**CITY OF ALBUQUERQUE  
PLANNING DEPARTMENT  
March 27, 2013  
DRB Comments**

**PROJECT # 1009636**

**APPLICATION # 13-70485**

**RE: Tract 492, Town of Atrisco Grant, Unit 1**

SKETCH PLAT OF
TRACT 492
UNIT 7
 TOWN OF ATRISCO GRANT
 PROJECTED SECTIONS 33, T.10N., R.2E., N.M.P.M.
 CITY OF ALBUQUERQUE, BERNALILLO COUNTY, NEW MEXICO
 MARCH 2013

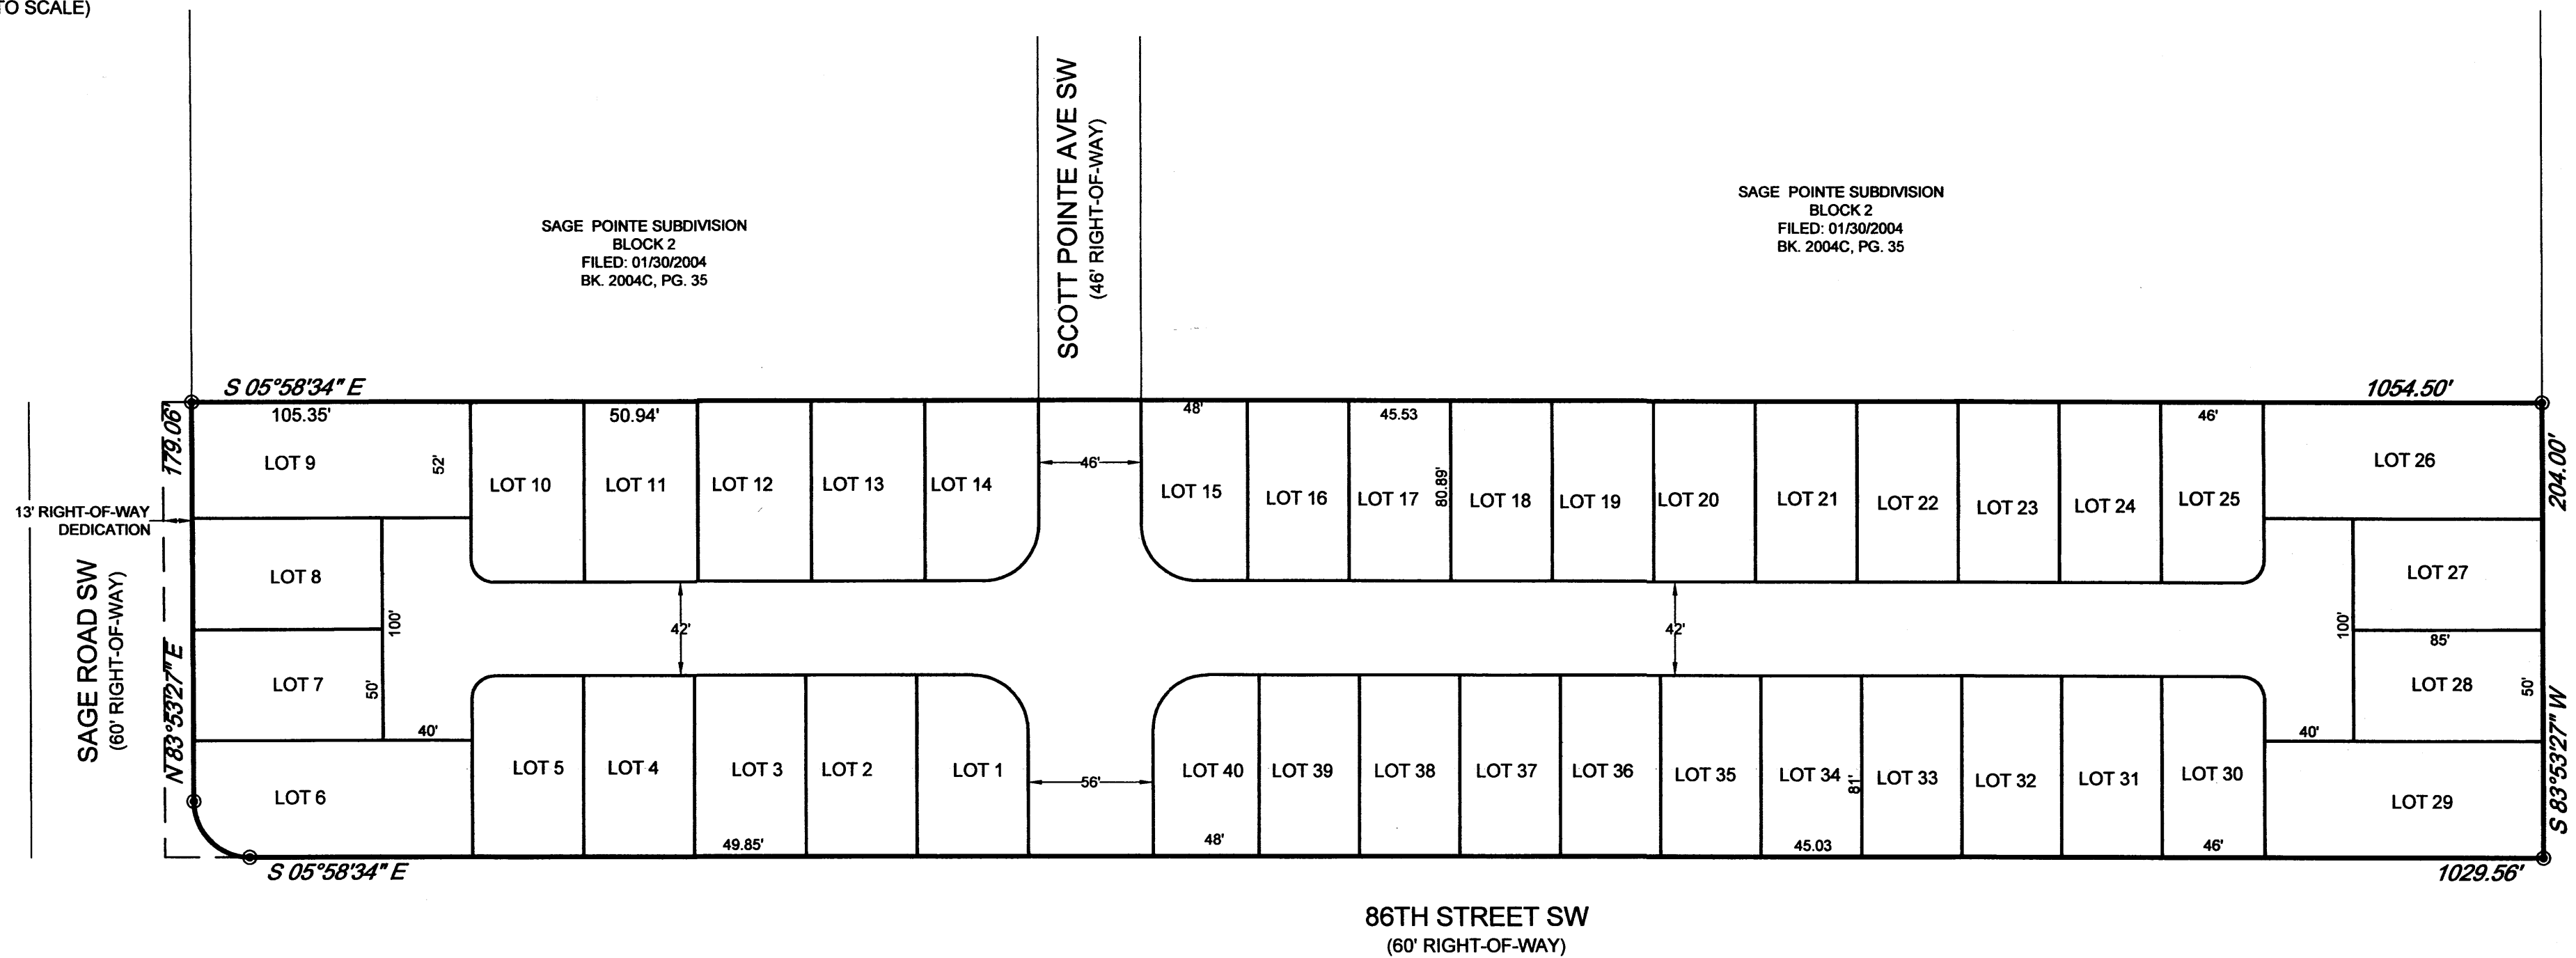
The site is zoned R-D/ 14 dwellings per net acre within the Tower/ Unser Sector Development plan. Compliance with the Open Space requirements of the R-D Zone must be demonstrated at the time of Preliminary Plat application, as well as Compliance with the Subdivision and Public Right of Way Regulations of the sector plan; it appears an additional access to Sage Rd SW will be needed.
